Advice on Environmental Impact Statement – State Significant Development

Proposal: Garoo Solar Farm and BESS

Major Project reference: SSD-79747209

Attachment A – Detailed Aboriginal cultural heritage advice

Survey Unit

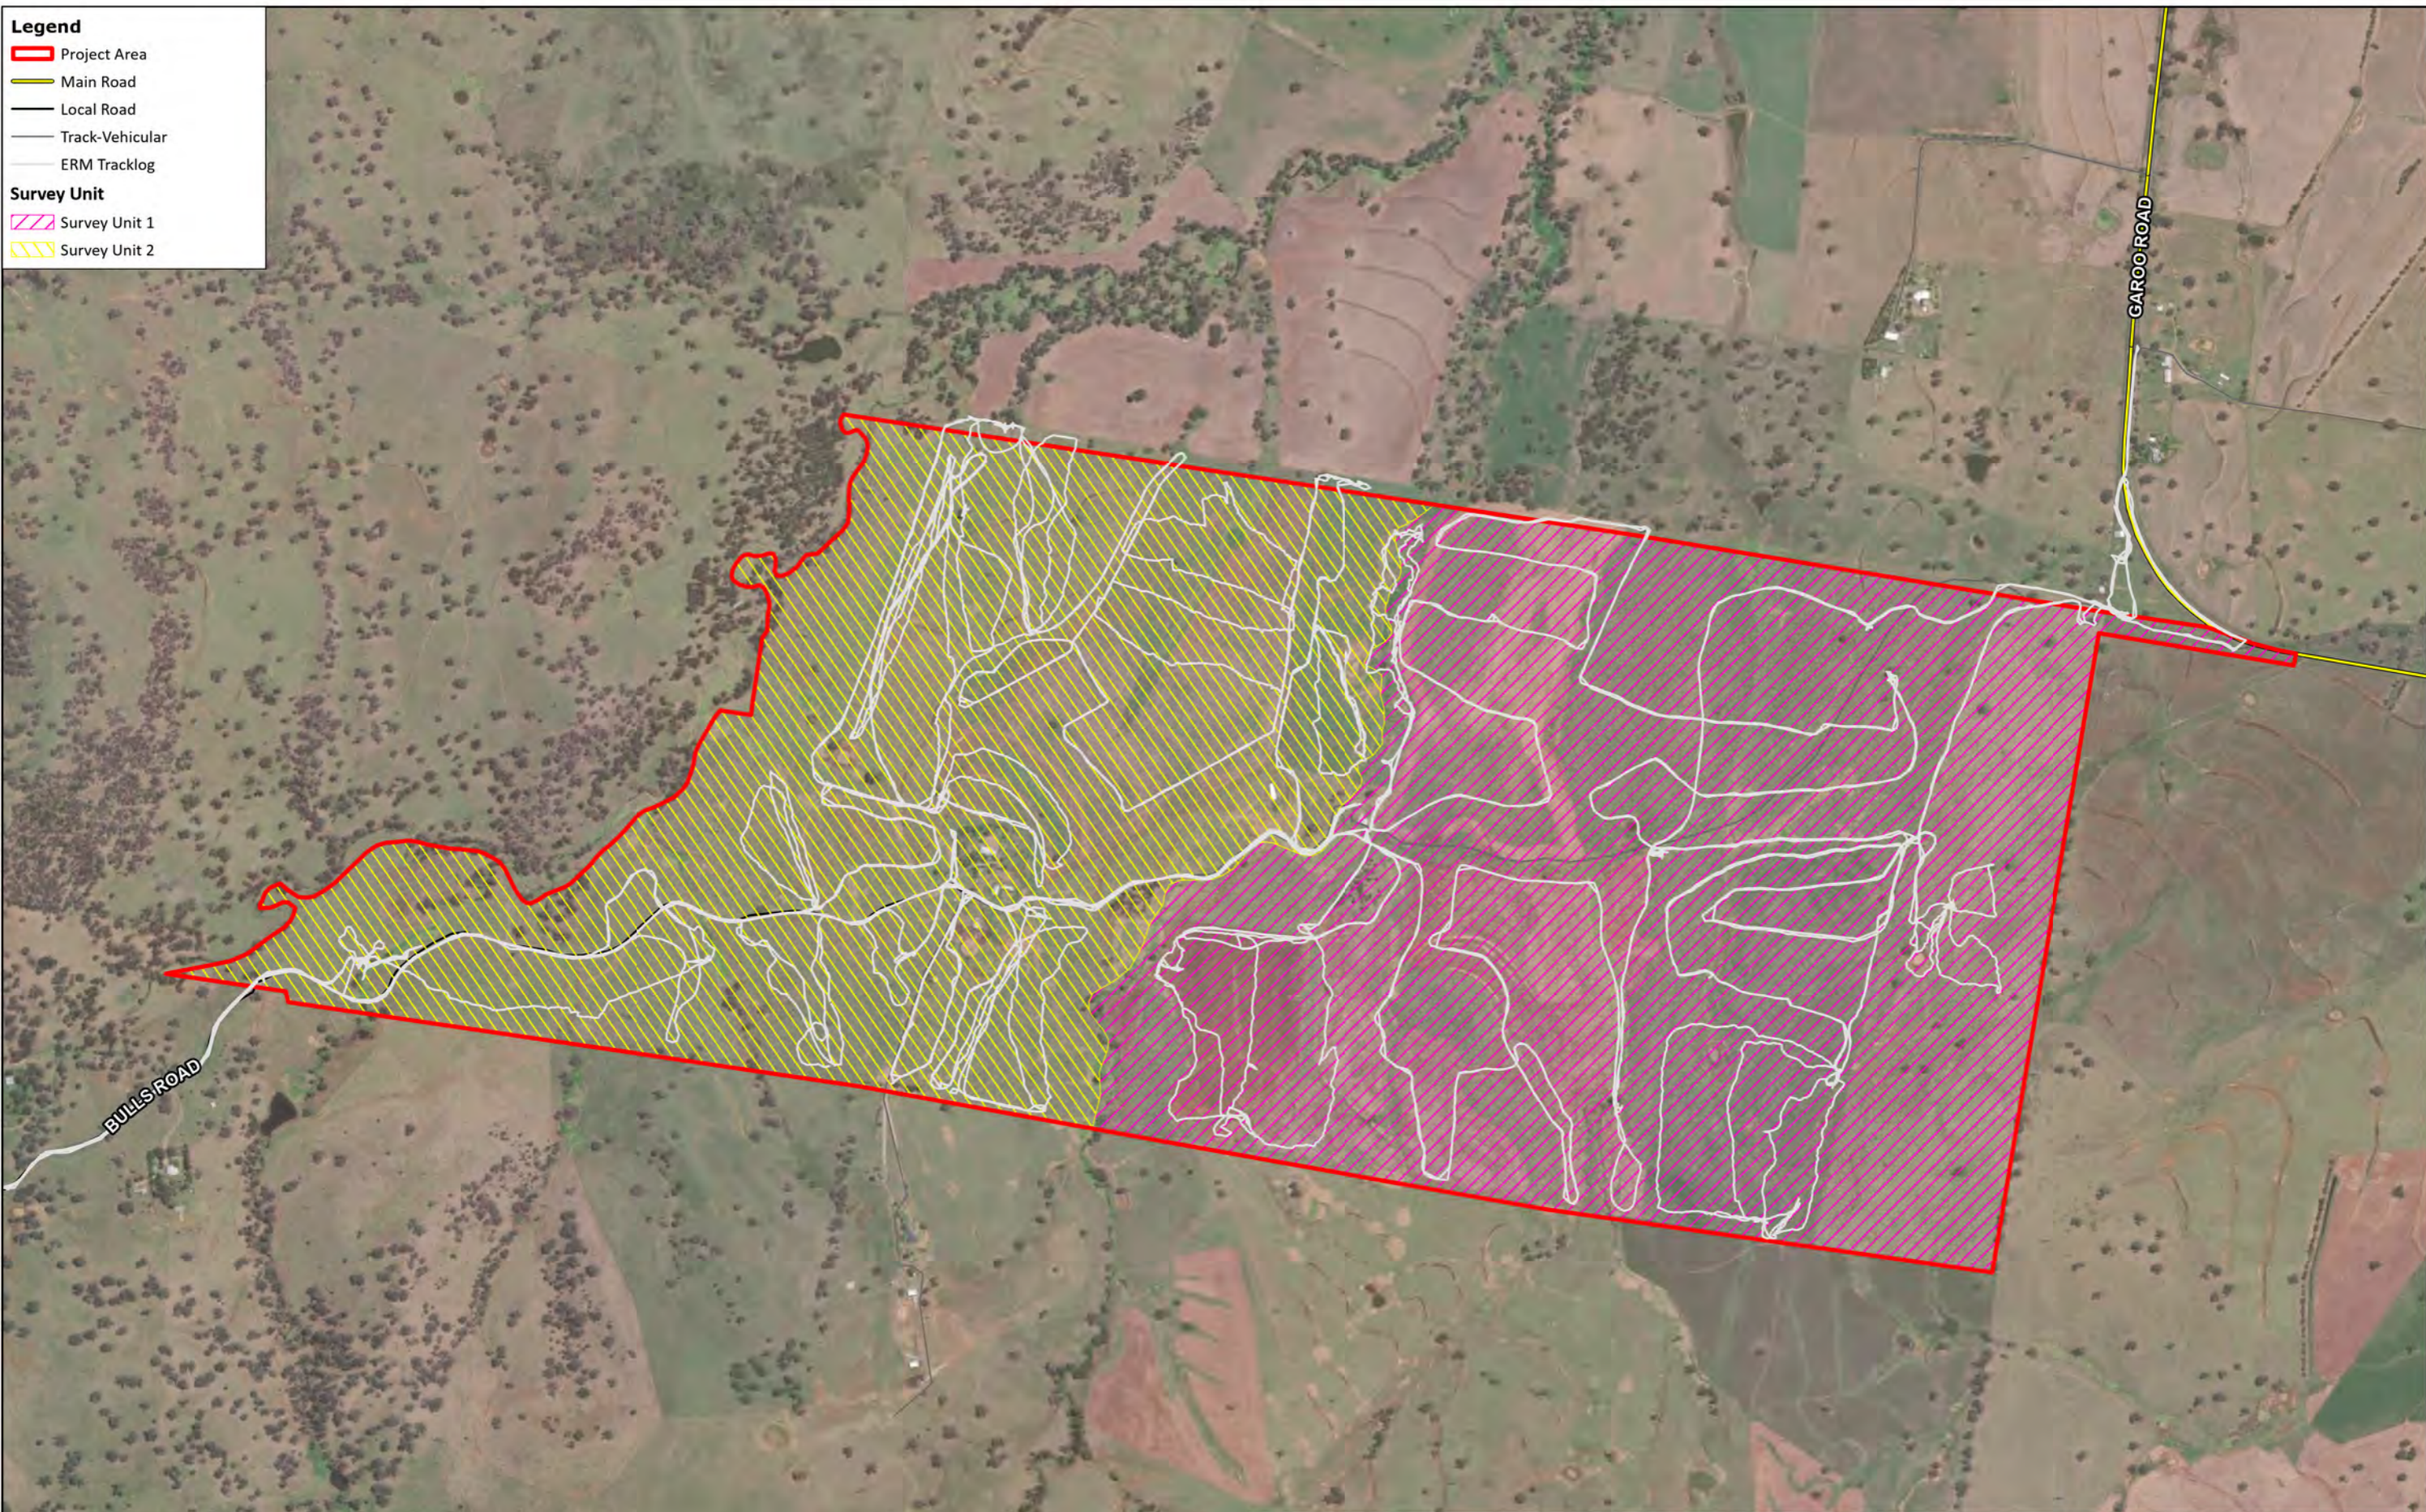
10. Further information and details are required on how survey units have been defined based on landforms as both SU1 and SU2 are characterised as having the same landforms, however Table 7-4 describes SU1 as an undulating slope landscape. Further to this, the visibility is stated as low, but Table 7-2 has visibility at 69% and effective survey coverage at 21%.
11. Heritage NSW recommends Table 7-3 is accompanied by a figure that outlines the landforms elements for each survey unit and the survey tracklogs to provide additional context.
12. Heritage NSW notes that survey did not occur along Sugarloaf Creek and that this area is currently excluded from impact. It is recommended that additional assessment, including survey and potentially test excavations, is conducted in this area design changes trigger direct impacts being proposed in this area.
